Subject: Exhibition – UNSW Health Translation Hub (SSD-10822510)

Thank you for your email received 17 May 2021 requesting comments on the above proposal. Environment, Energy and Science Group (EES) has the following comments.

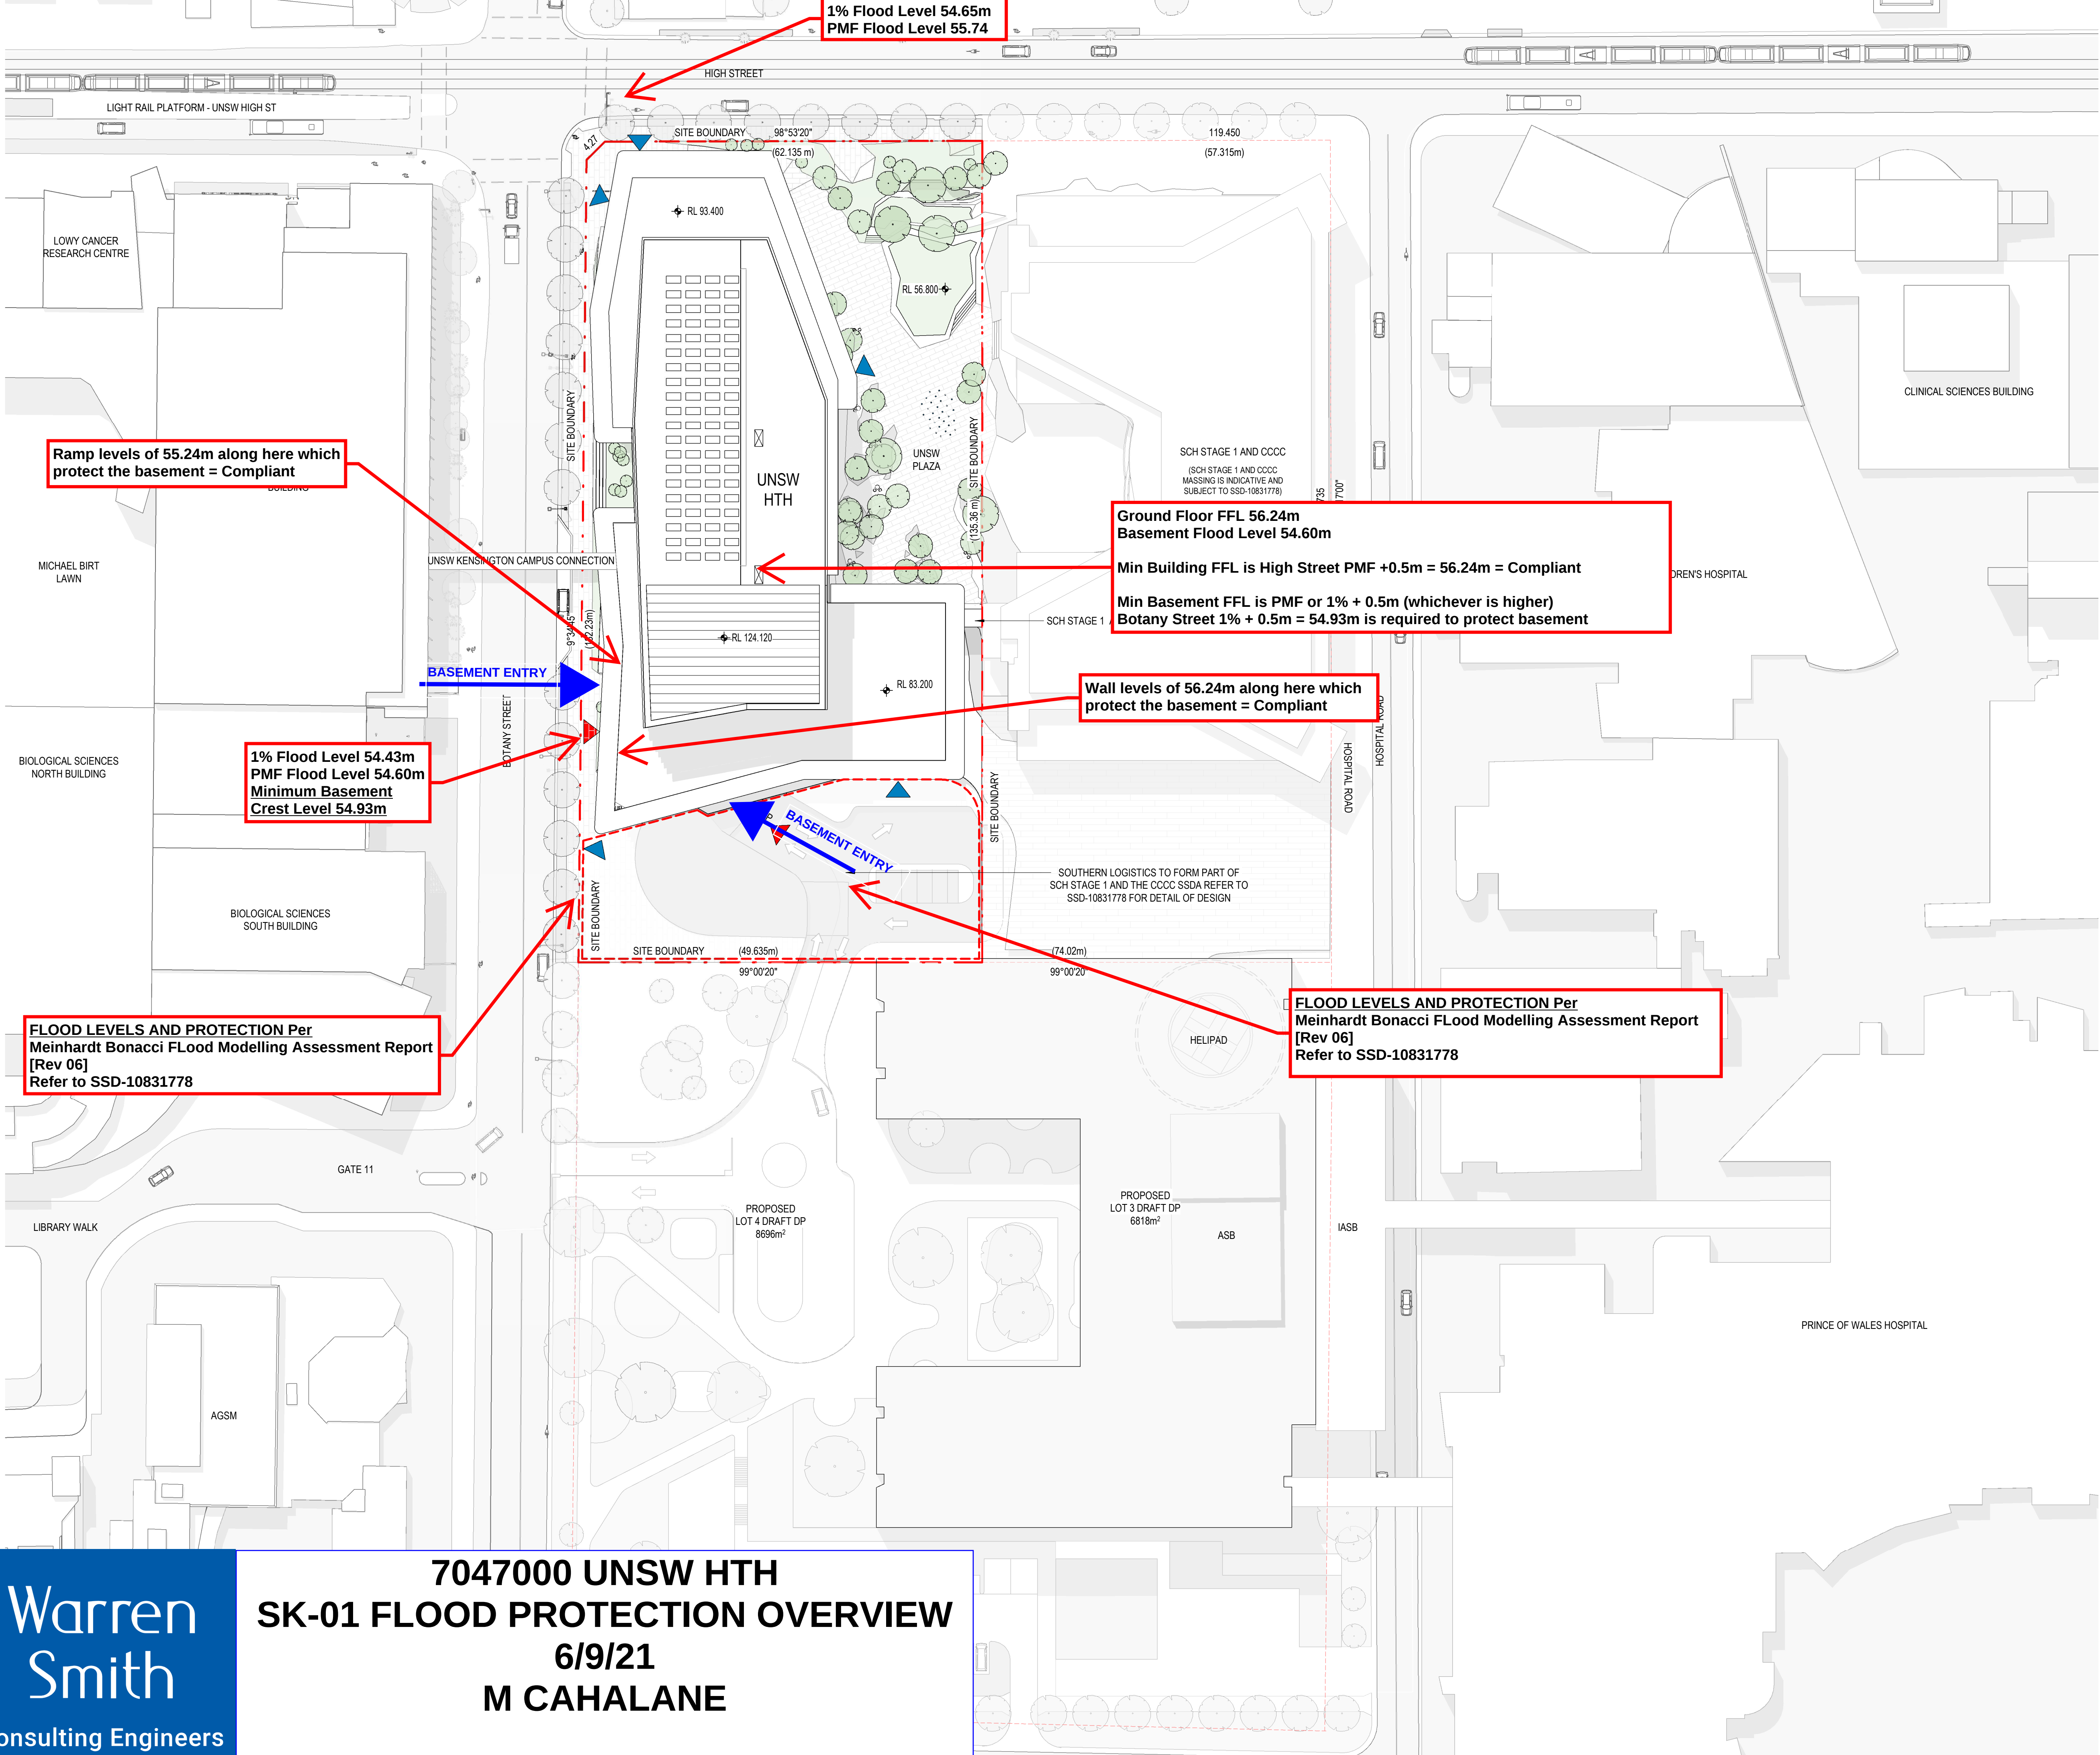
A basement is proposed for the loading dock, bicycle storage and plant. The proponent must describe how the basement is protected from flooding at the PMF level or 1% annual exceedance probability event level plus 500mm freeboard.
